Friday 6th September 2019

Mr Richard Price
Case Officer A303 Stonehenge - Planning Inspectorate
Via email to richard.price@pins.gsi.gov.uk and A303Stonehenge@pins.gsi.gov.uk

Confirmation and queries of points raised at the PINS A303 Stonehenge hearings on 21st & 29th August 2019 and other matters

Drawing file: TR010025 / TR010025-001531-Figure 7.102.pdf

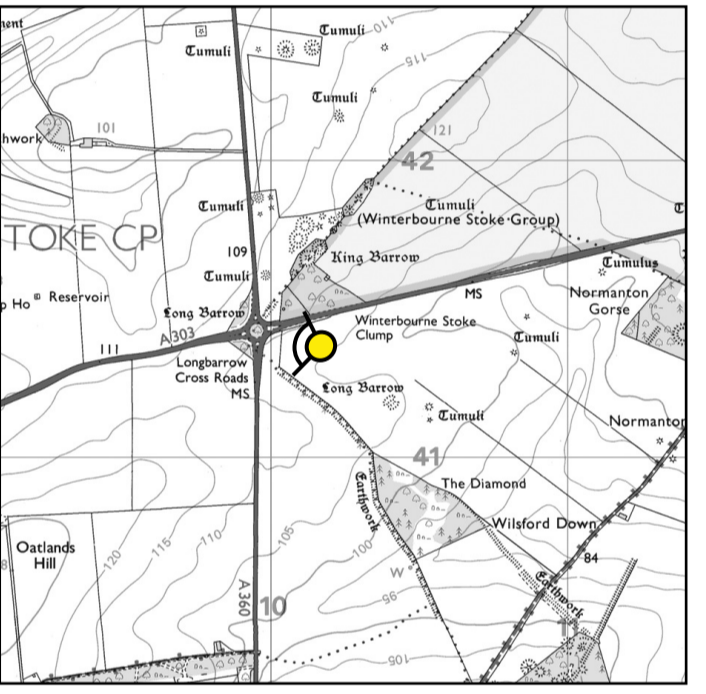
In addition photomontages 7.102, 7.107 and 7.91 are all in error and require redrawing.

7.102 fails to show the layout for the regular contraflow arrangements and the signage relevant.
